Response to Comments on Cambridgeshire County Council's LIR at Deadline 2

This document sets out Cambridgeshire County Council's (**CCC**) response to comments on Cambridgeshire County Council LIR submitted at Deadline 2 (D2). The table below references the relevant paragraph and page number.

Deadline 2 (D2) Submission - 8.11 Applicant's Comments on Local Impact Reports [REP2-036]

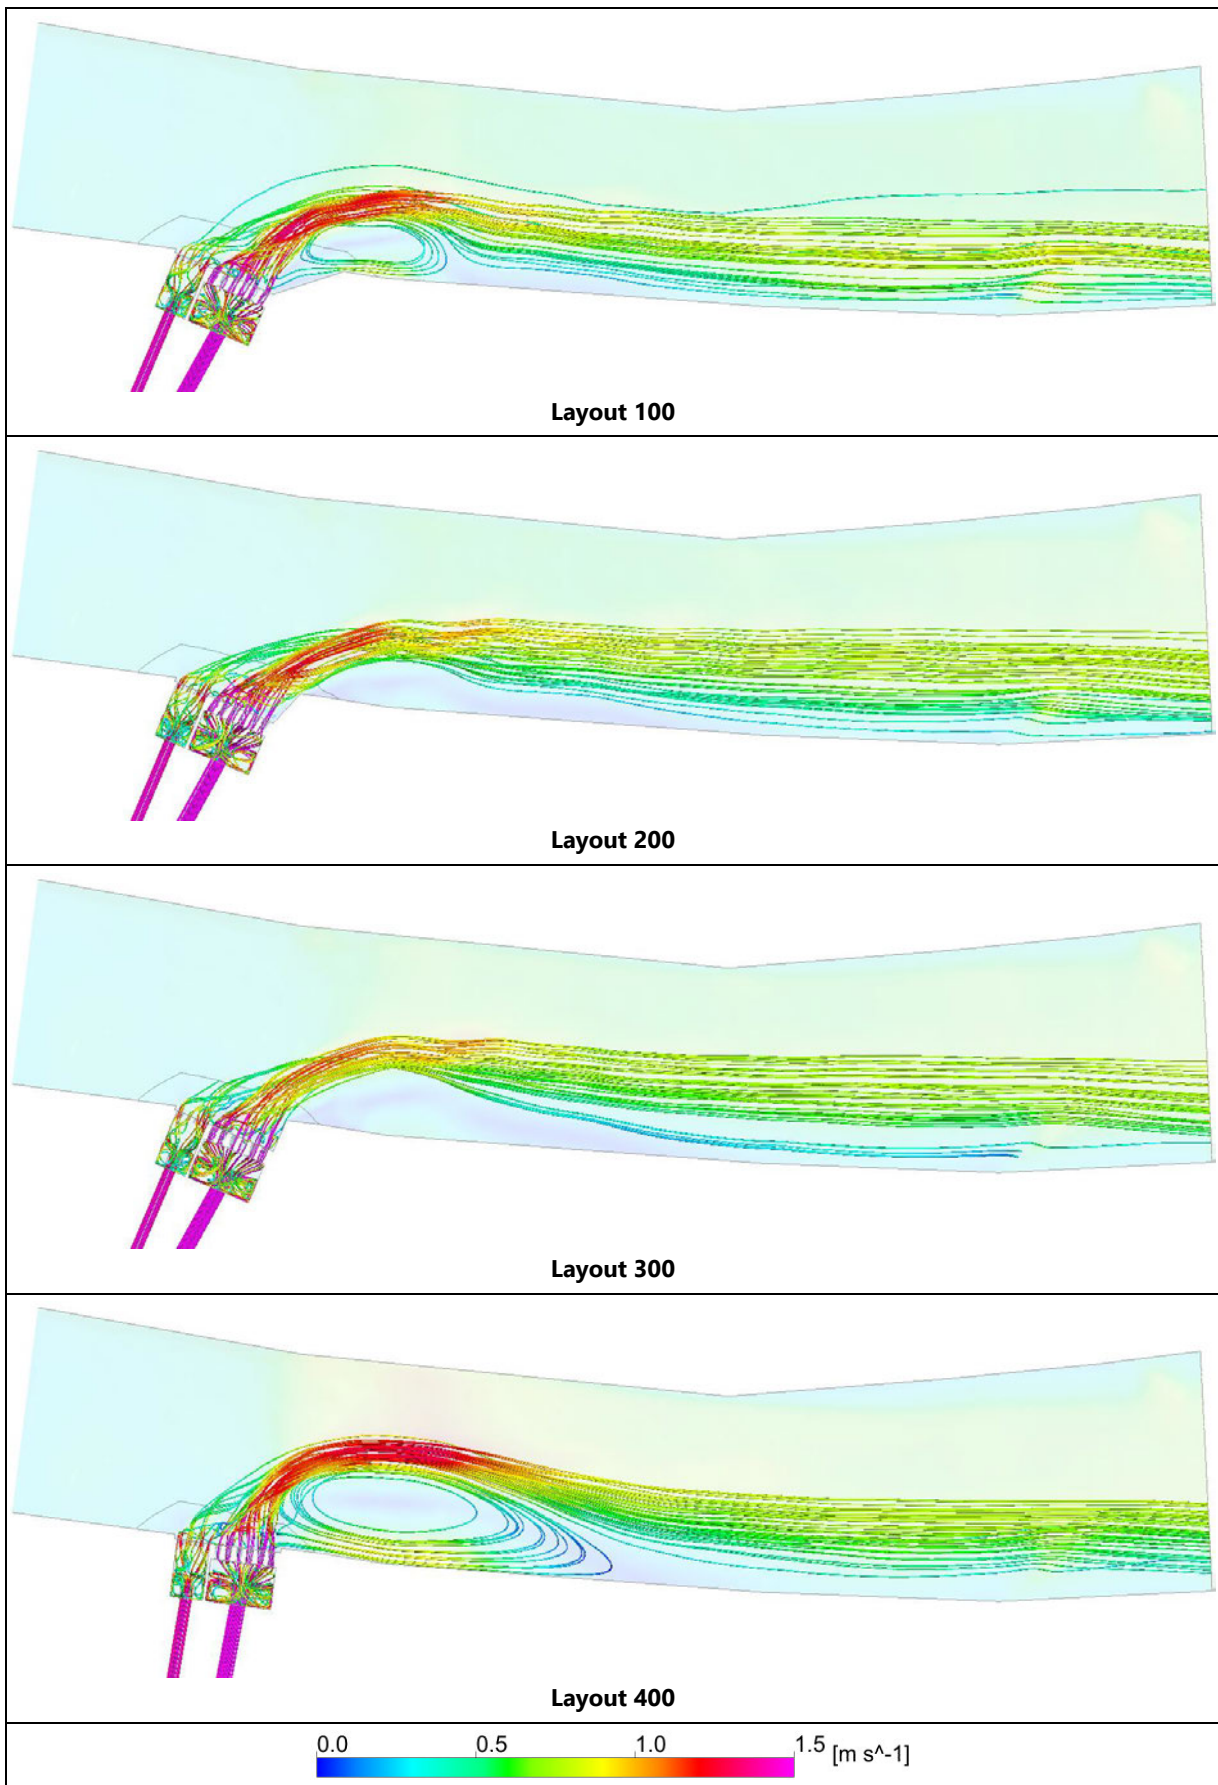
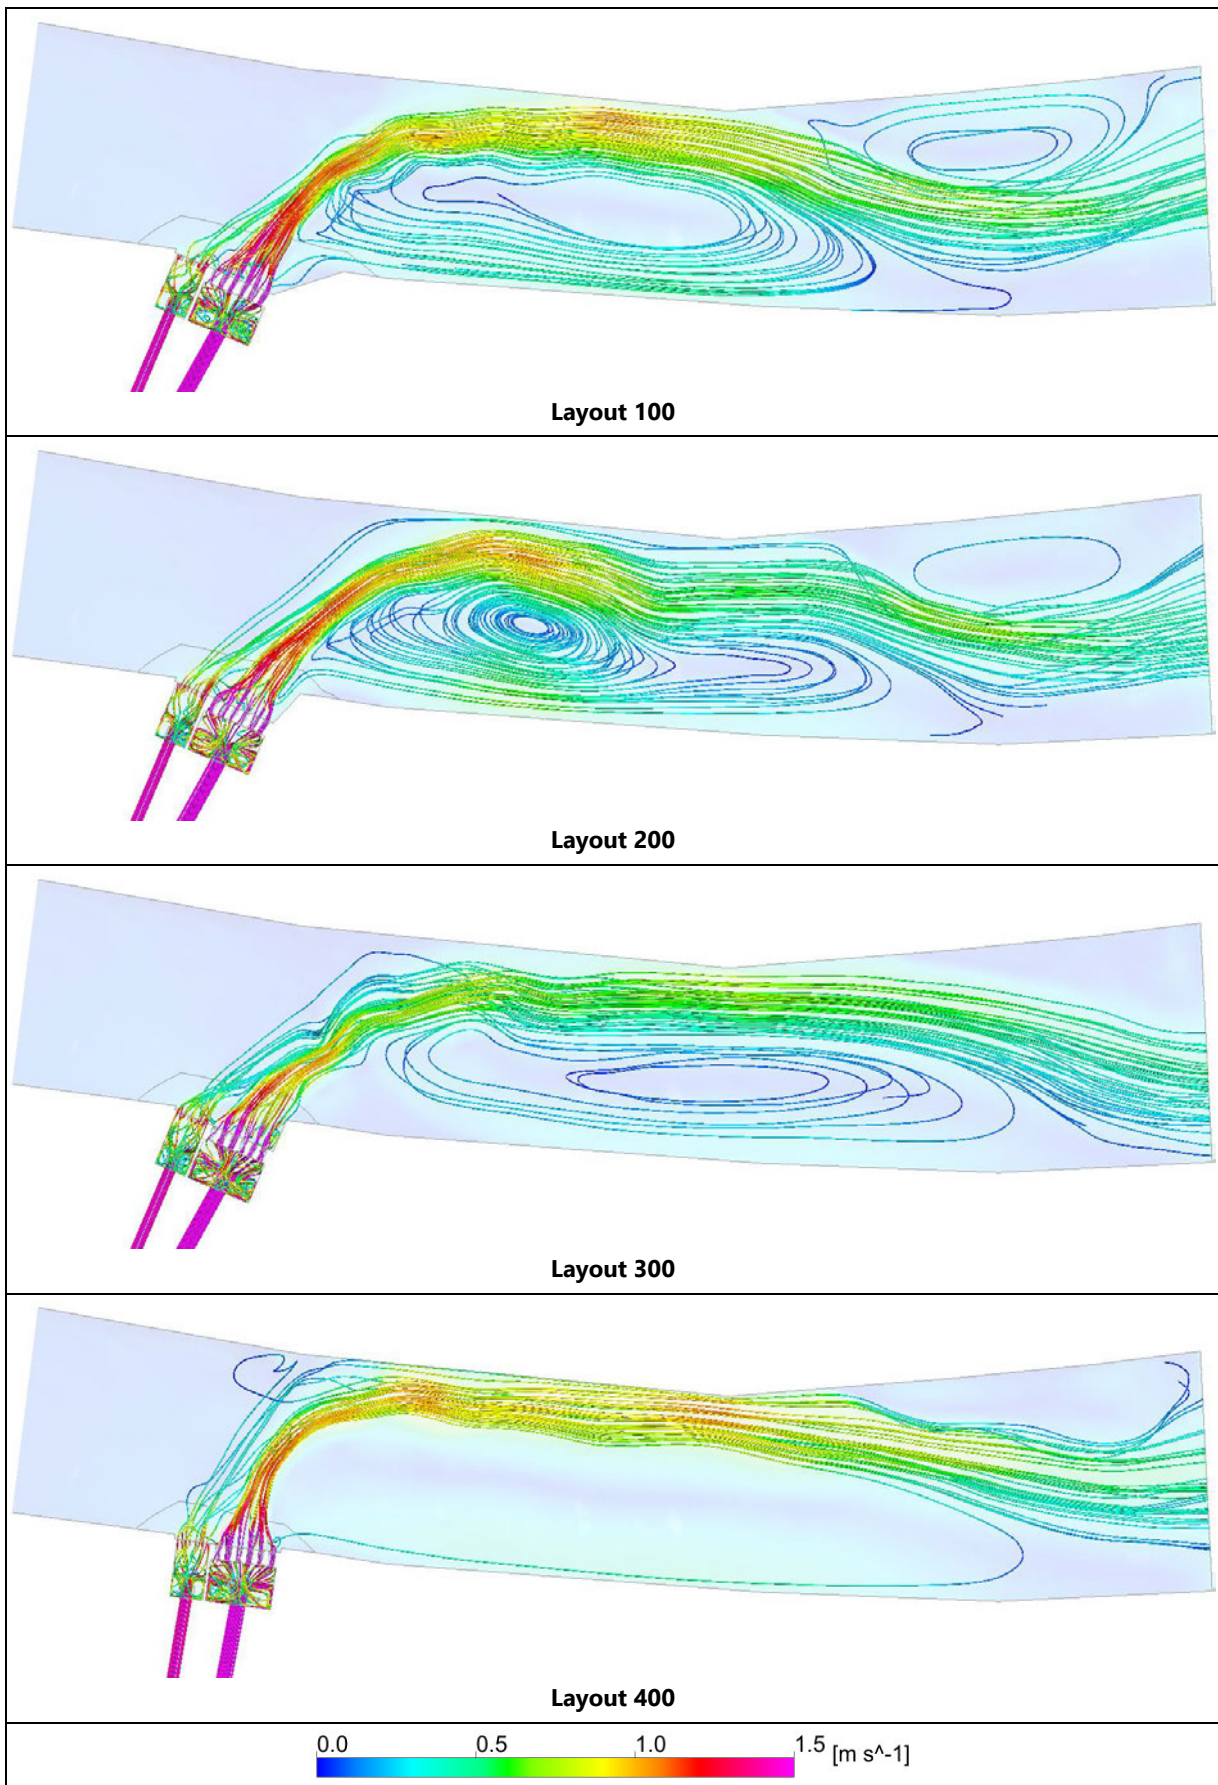
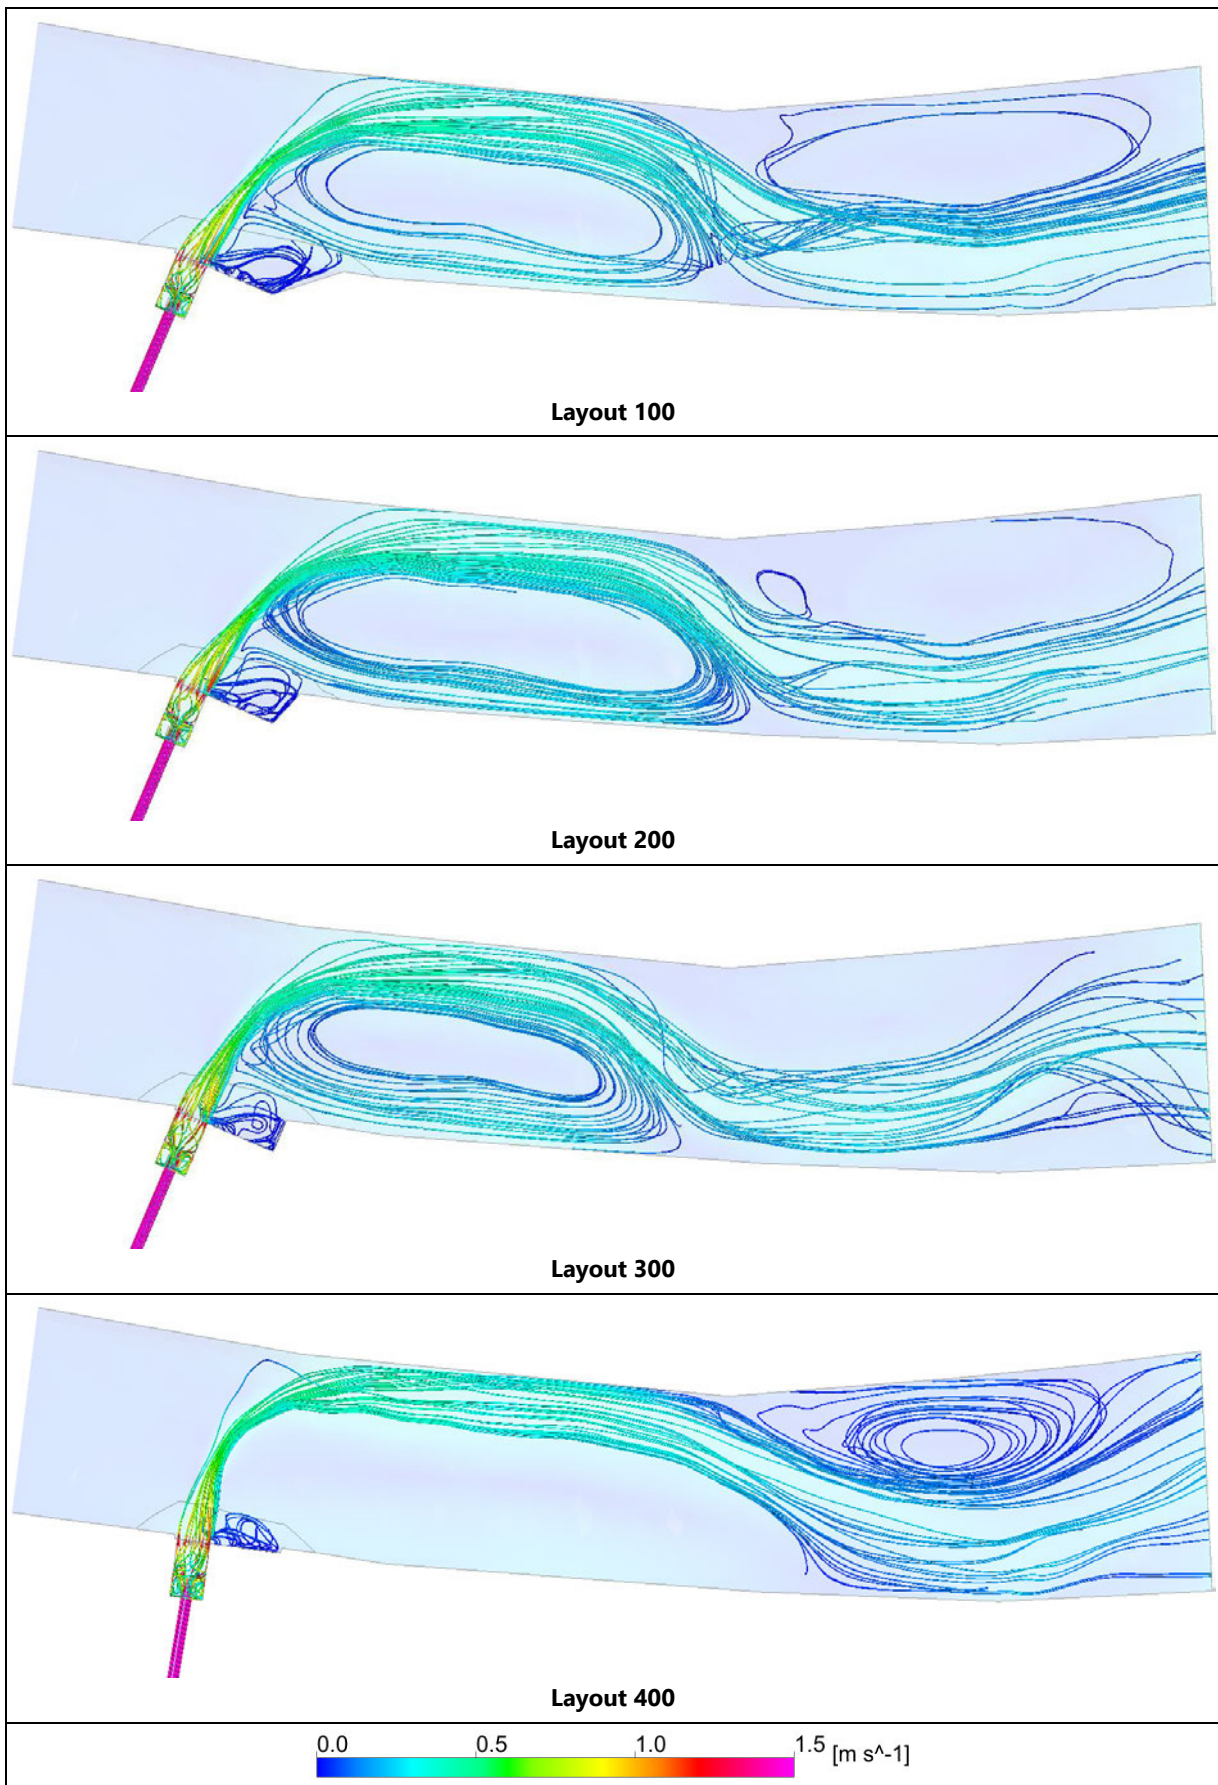
3. Biodiversity – Response to paragraphs 5.53 and 5.54	Page 31	Resolved. The Council welcomes confirmation that scouring of River Cam and impact on habitat quality will be monitored through the Outfall Management and Monitoring Plan.
12 – Water Resources	Page 39	The County Council concerns remain as outlined in the LIR and in our recent submission at Deadline 2 [REP2-041].
11 Transport and Traffic	Page 38	RE: Cambridgeshire County Council LIR para 13.36. The County Council does not see how the addition of highway status to the schedules in the DCO could lead to any confusion, as the Applicant contends. RE: CCoC LIR para 13.37. The County Council acknowledges that s59 HA1980 is not disapplied by the DCO. However, in the interests of cooperative working and with the intention of saving both the County Council and the Applicant costs in both time and resource in the future, it is felt that agreement should be reached now that any damage to the highway network that is attributable to the operation of the development will be repaired at cost to the Applicant. RE: CCoC LIR para 13.40. The County Council acknowledges that there is only one proposed new PROW. The creation of a new highway of any type results in new maintenance burdens and legal obligations being inherited by the LHA. Therefore, the Council does not think it is unreasonable to expect some form of protective provisions to apply to the creation of the proposed new bridleway.
